From: Anita Gardner
Sent: 06 April 2017 16:18
To: Karen Parsons
Subject: FW: White Lodge Rectory Lane Angmering - A/207/16/HH and A/208/16/L

I have substituted the submitted plans for the originals and have discussed the revised plans with Dr Wightman. The design of the actual extension is now acceptable. His only remaining concern is the amount of wall being removed on the ground floor, especially under the beam.

Ground Floor Plan
as existing

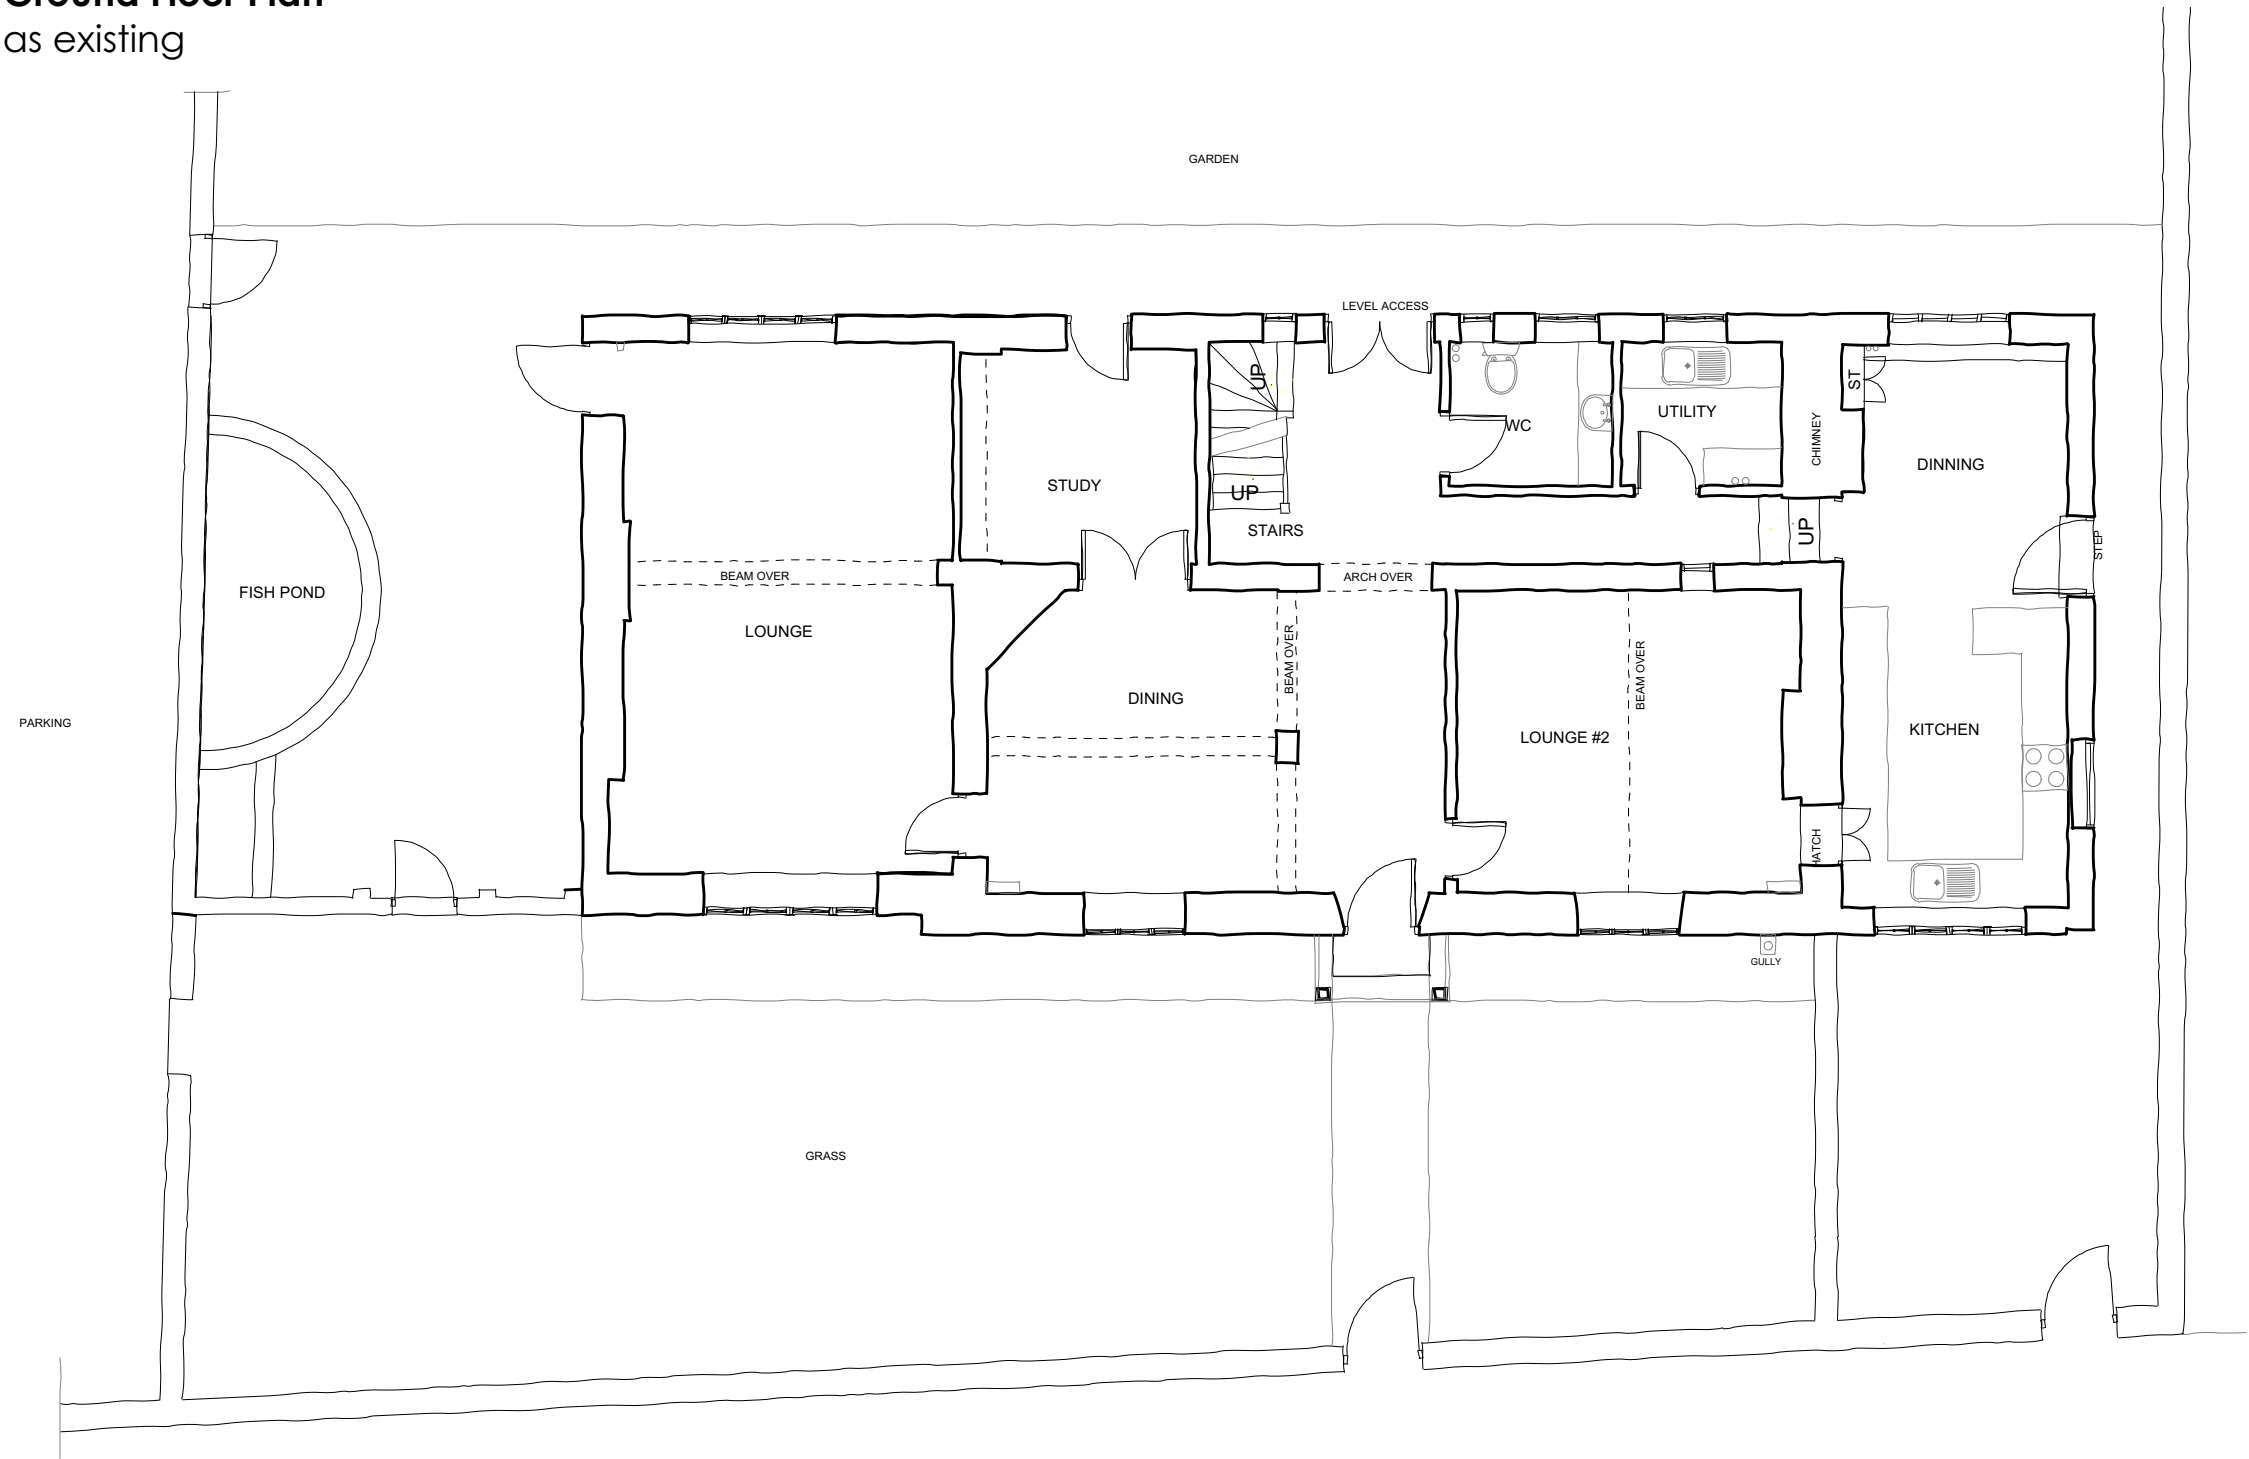
He would rather see the ground floor layout plan amended to retain the side wall of the dwelling up to the limit of the family room with only the dining area open to the kitchen.

Without prejudice I would appreciate receipt of an amended floor plan to detail this area of walling retained.

I am pleased that at last we have an agreed form of external structure however I am very unhappy about the change in his direction on the size of the ground floor internal walls. This was discussed at length with him with my heritage assessor and architect and they agreed that a Nib was required that would show the difference in the two structures and times of construction. This we have clearly done by in two ways 1. By stepping back the line of the extension from the original house both front and back and 2. by keeping enough of the internal walls to show that there was a wall here previously.

The whole principle for the extension is to create a large space for open plan living with a room that is current with the way in which a family house of this size now lives. I am very adamant that this wall is removed to the size as we proposed because to close the room off in the way he suggests would make this room and this sense of space unworkable. We have been extremely accommodating throughout this process and amended everything he has asked for but I feel that I really must at some point take a stance and I feel that his request is not reasonable and does make the extension work.
